Planning Inspectorate (the Drovers Solar
Farm)

Reference: OR-0009338/01
Customer reference: EN0110013

**Deadline 3 submissions response letter
The Drovers Solar Farm**

DRAWING TITLE:
Figure 12.12: Drinking Water Protection Designations

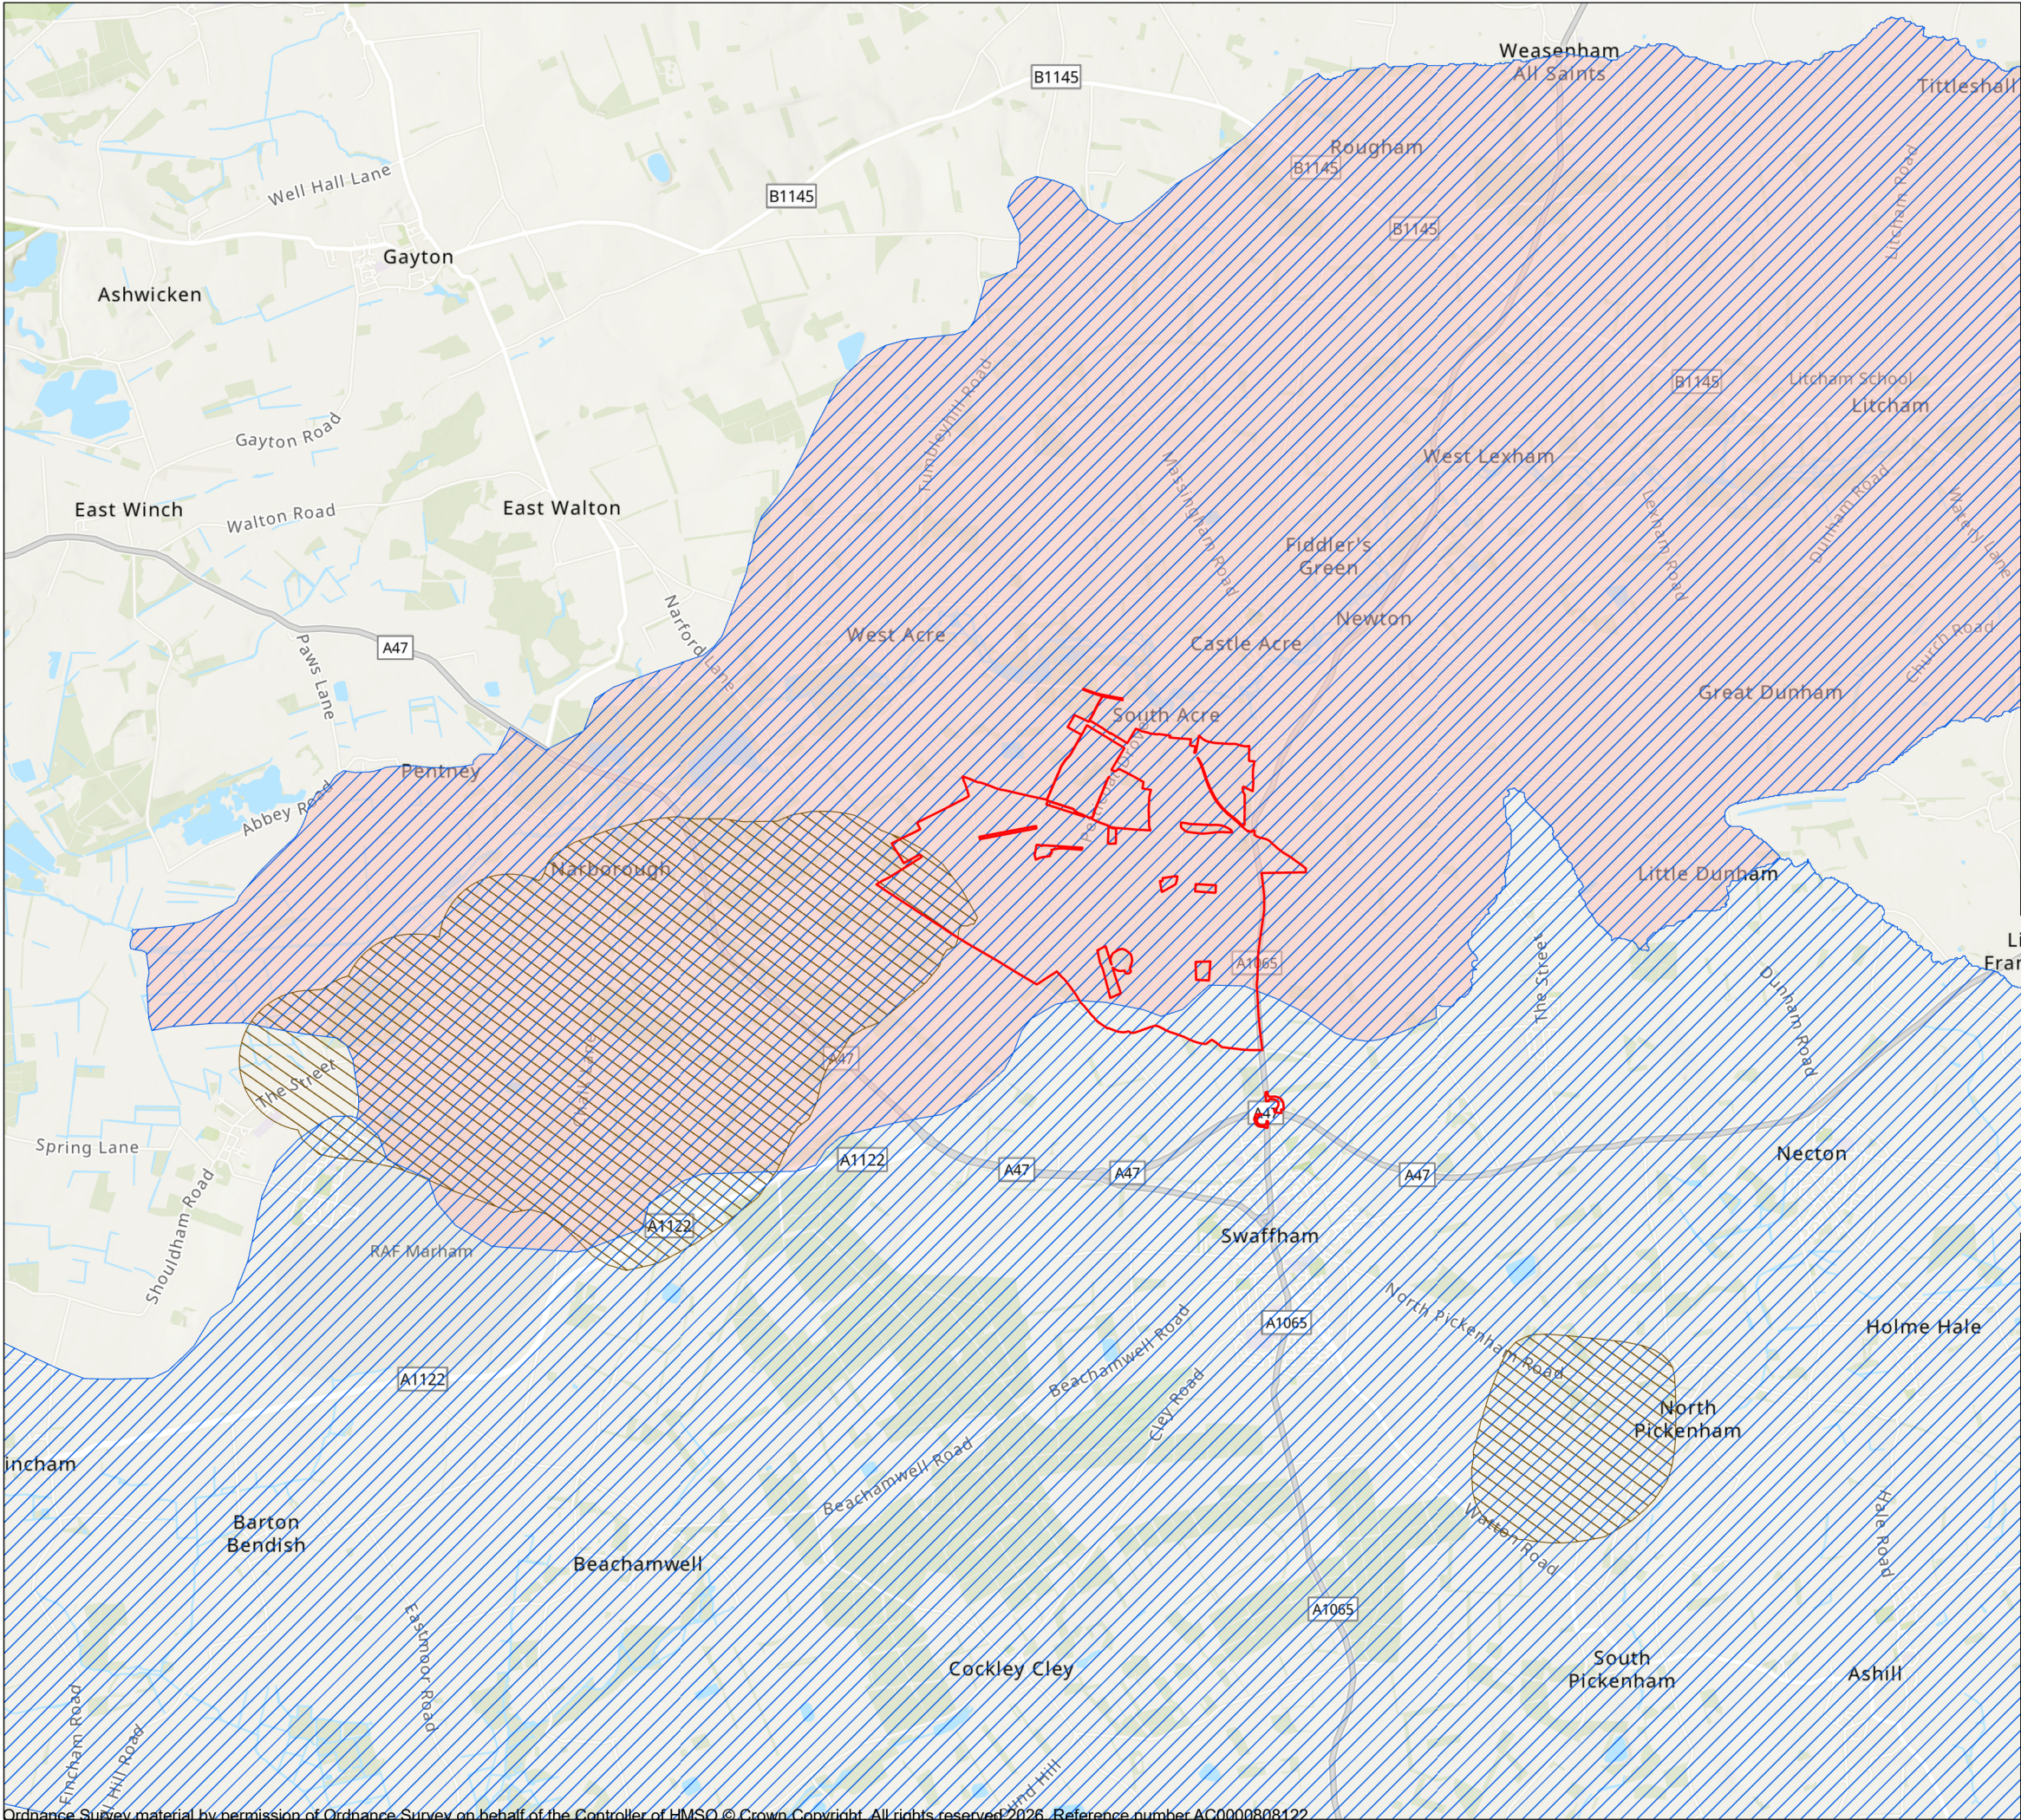
We were concerned that Figure 12.12 [\[APP-126\]](#) does not show all of the drinking water protection designations, including the Drinking Water Surface Water Safeguard Zone and Drinking Water Groundwater Safeguard Zone. The reader is therefore unable to see these designations in the context of the draft Order Limits.

6.3.1 ES Figure 12.12 Drinking Water Protection Designations [\[REP3-042\]](#) has been updated sufficiently.

DRAWING TITLE:
Figure 12.14: Work No. 3 Maximum Potential Foundations and Groundwater Elevations

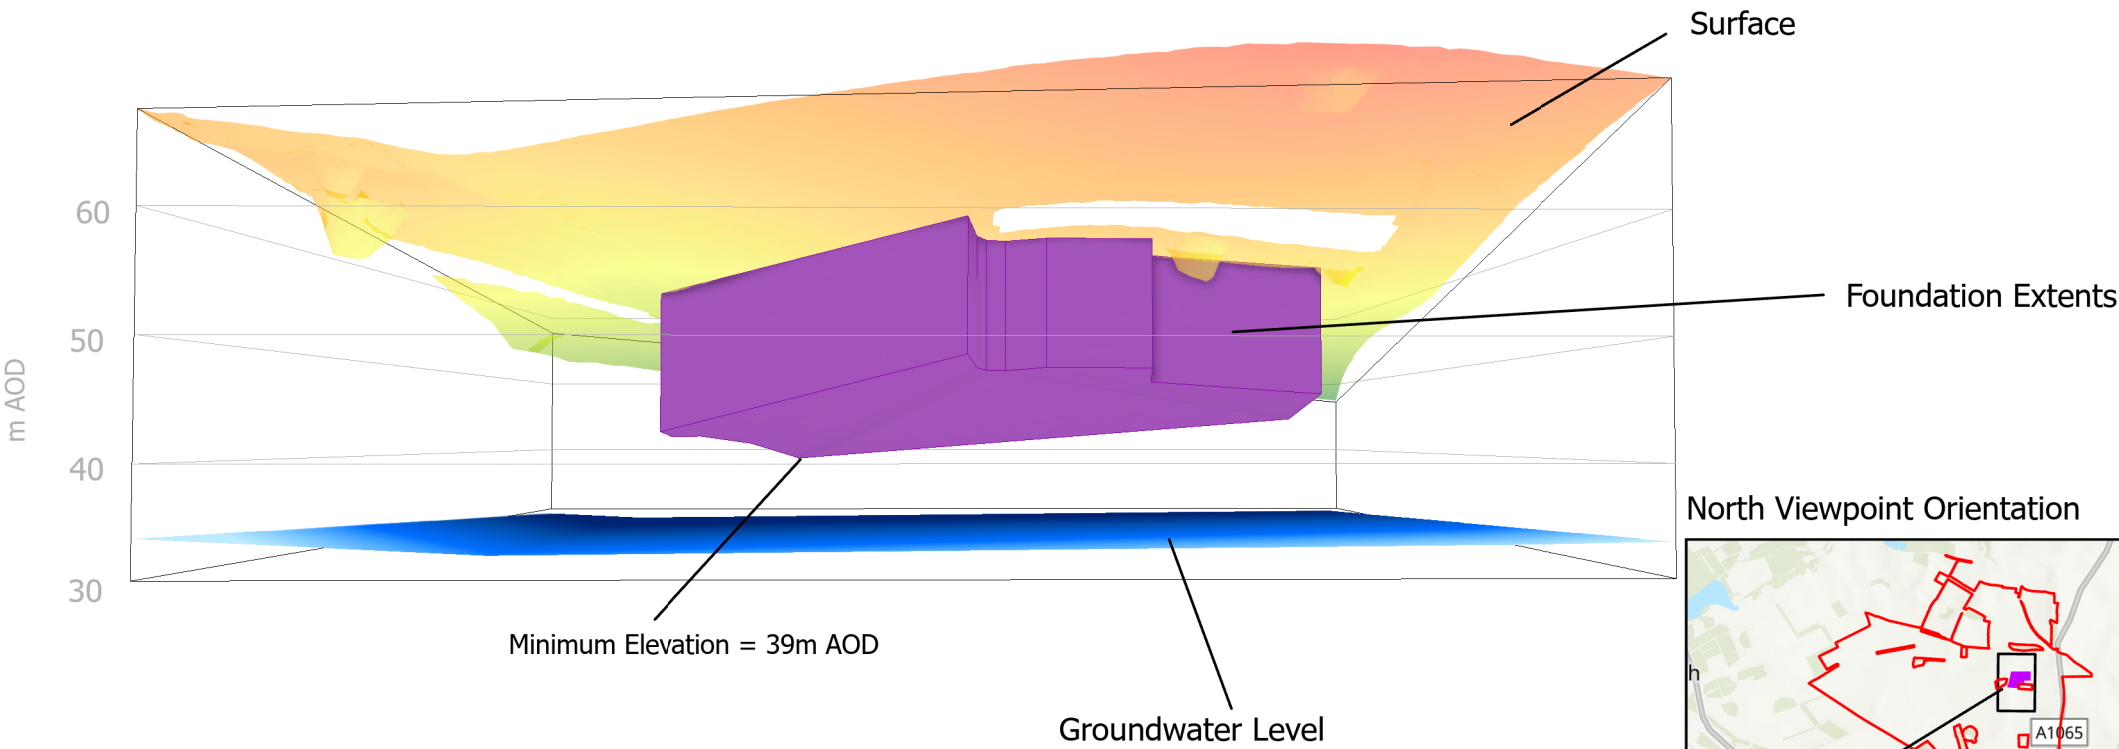
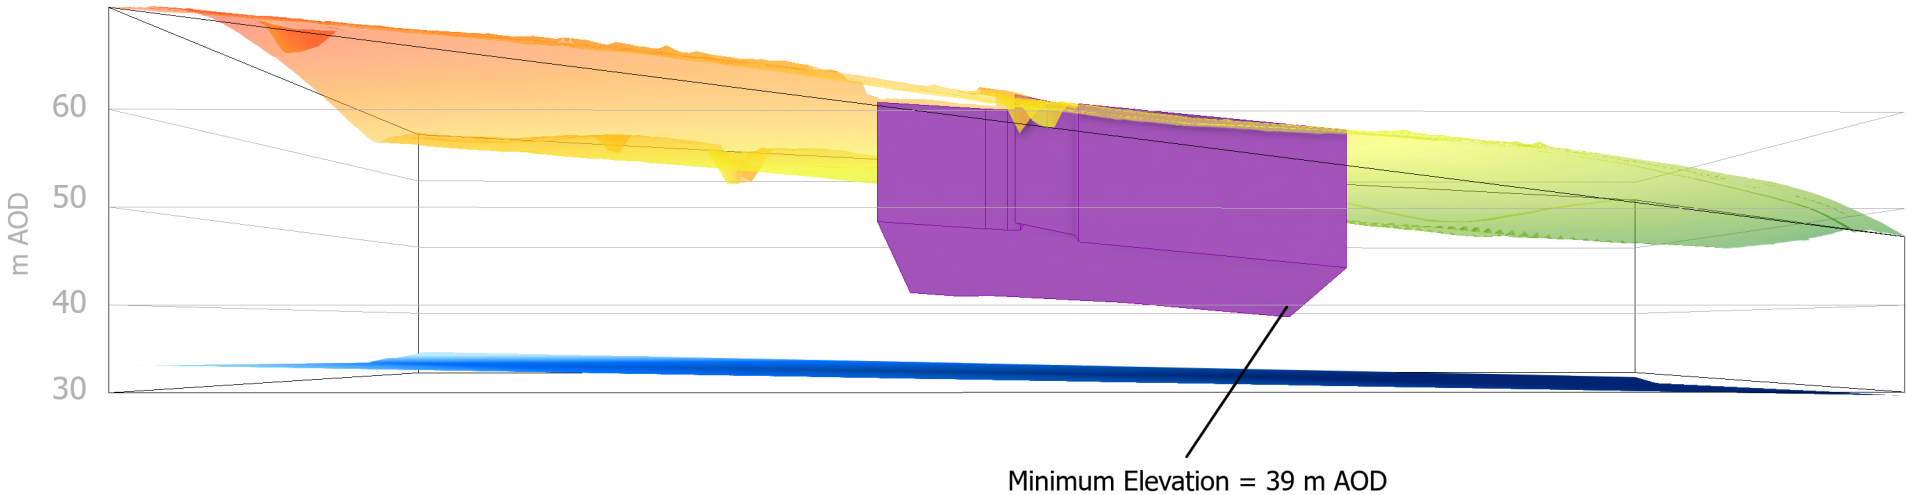
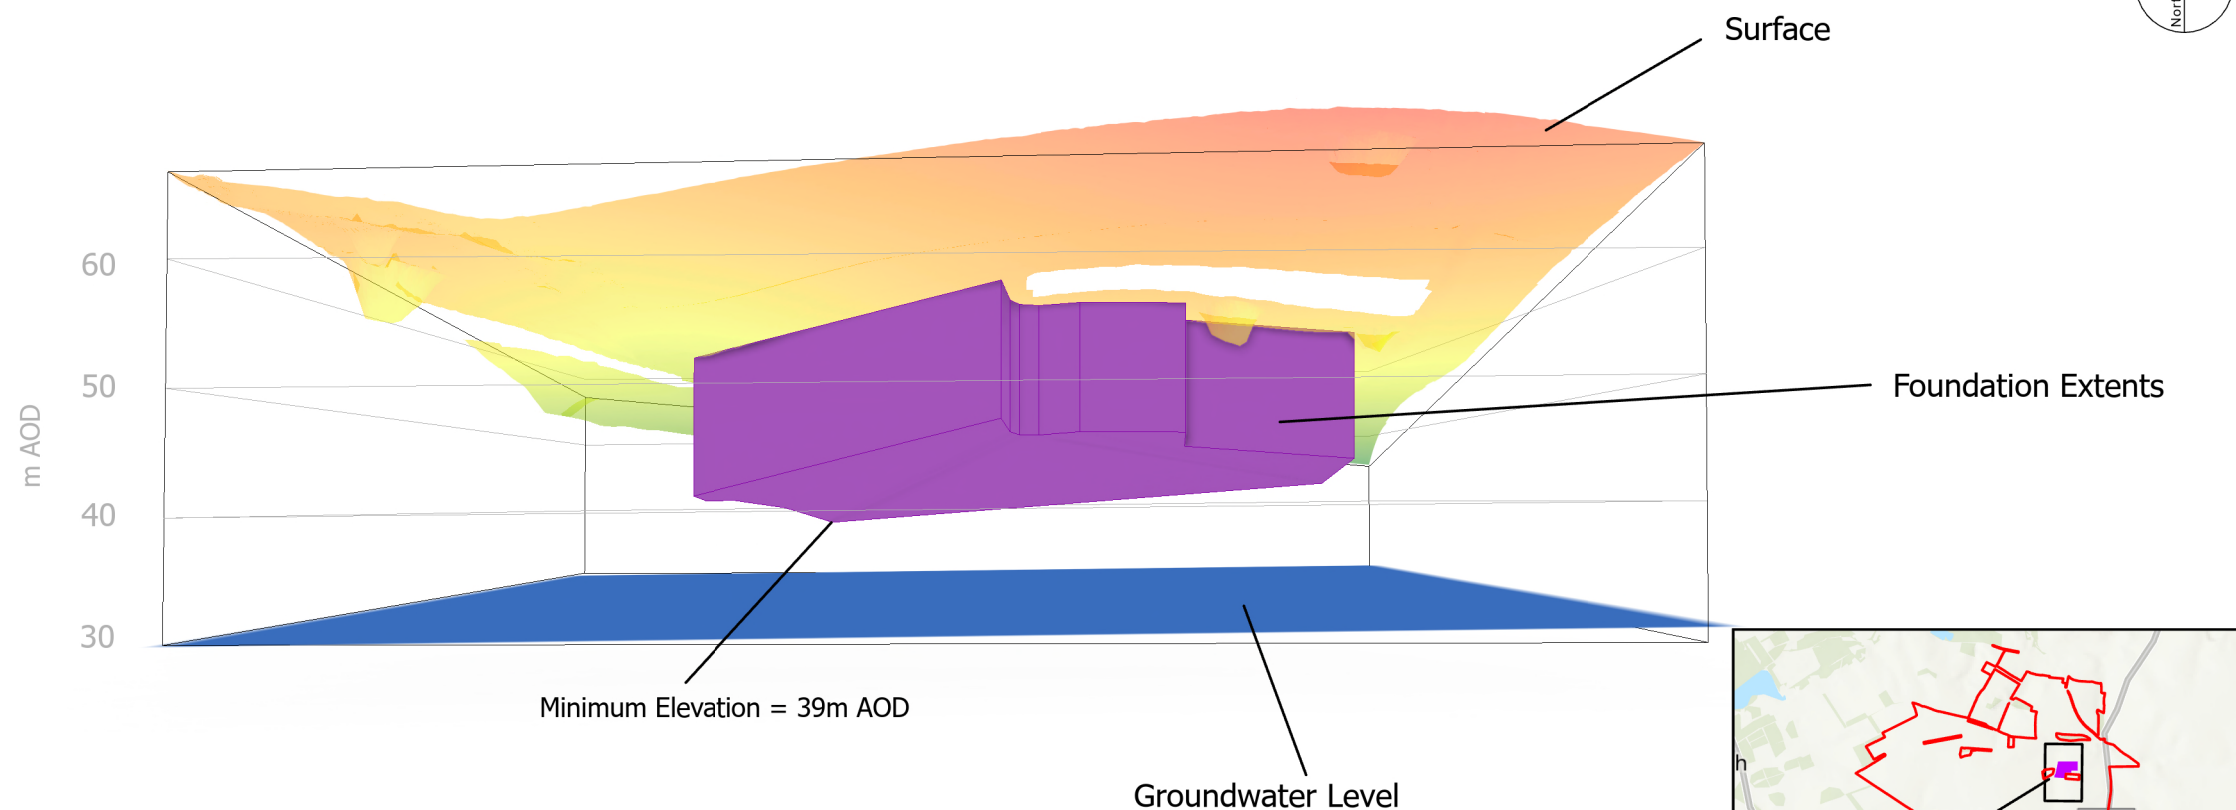
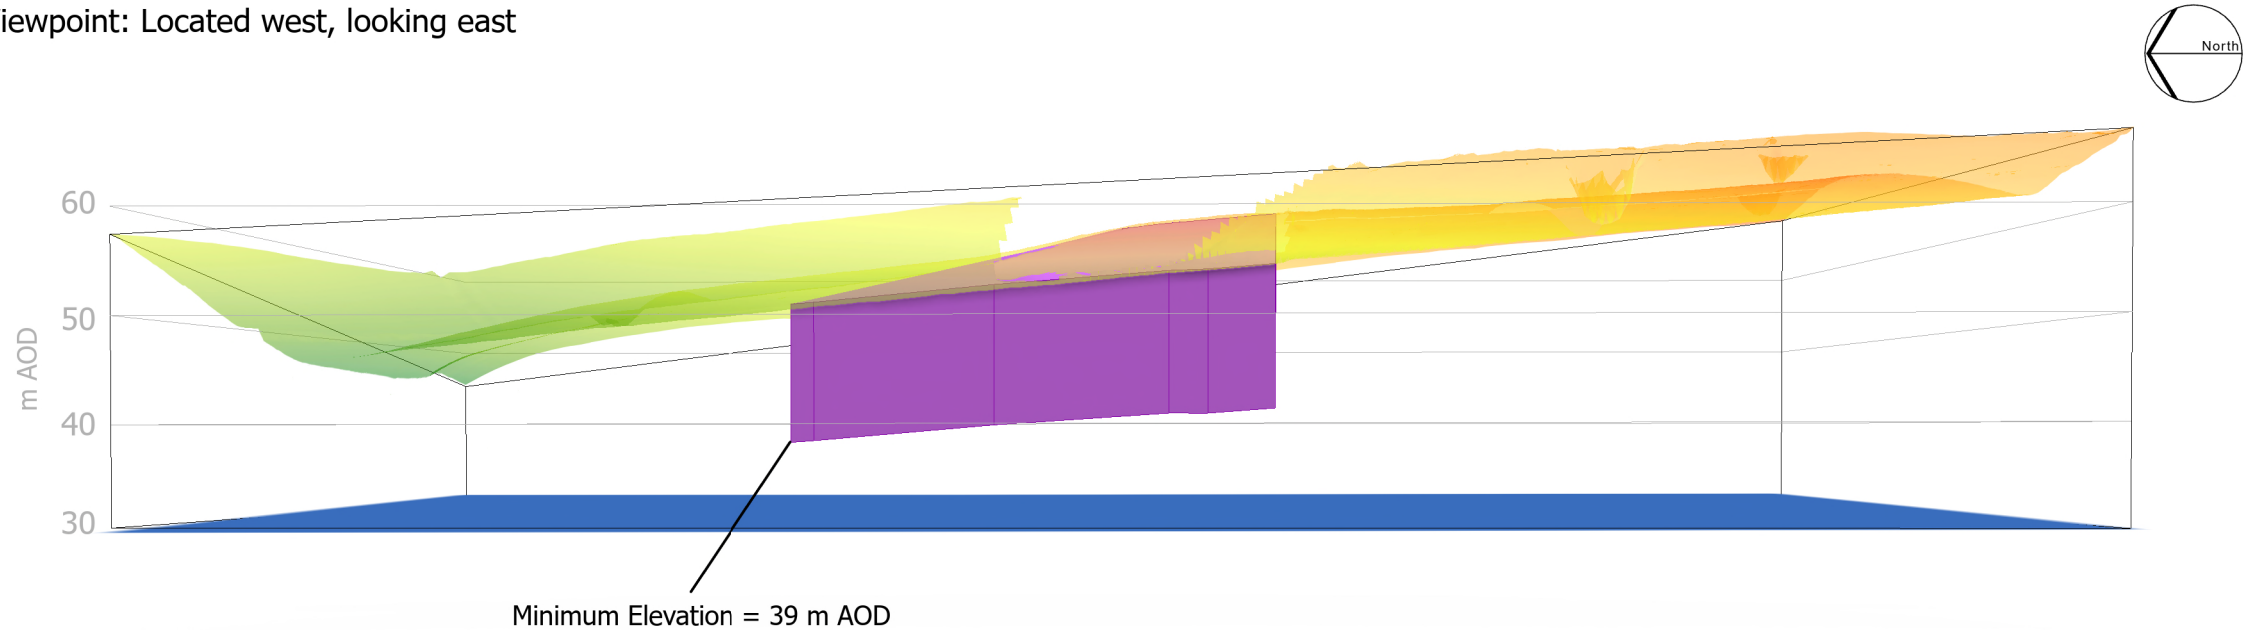
We were concerned that figures 12.13 [[APP-127](#)], 12.14 [[APP-128](#)], 12.15 [[APP-129](#)] and 12.16 [[APP-130](#)] do not clearly define the area represented by the drawings, including view orientation, or the elevation values.

- 6.3.1 ES Figure 12.13 Work No. 2 Maximum Potential Foundations and Groundwater Elevation [[REP3-043](#)]
- 6.3.1 ES Figure 12.14 Work No. 3 Maximum Potential Foundations and Groundwater Elevation [[REP3-044](#)]

We find the updated figures satisfactory for defining the 3D model view, and elevation the maximum extent of the foundations.
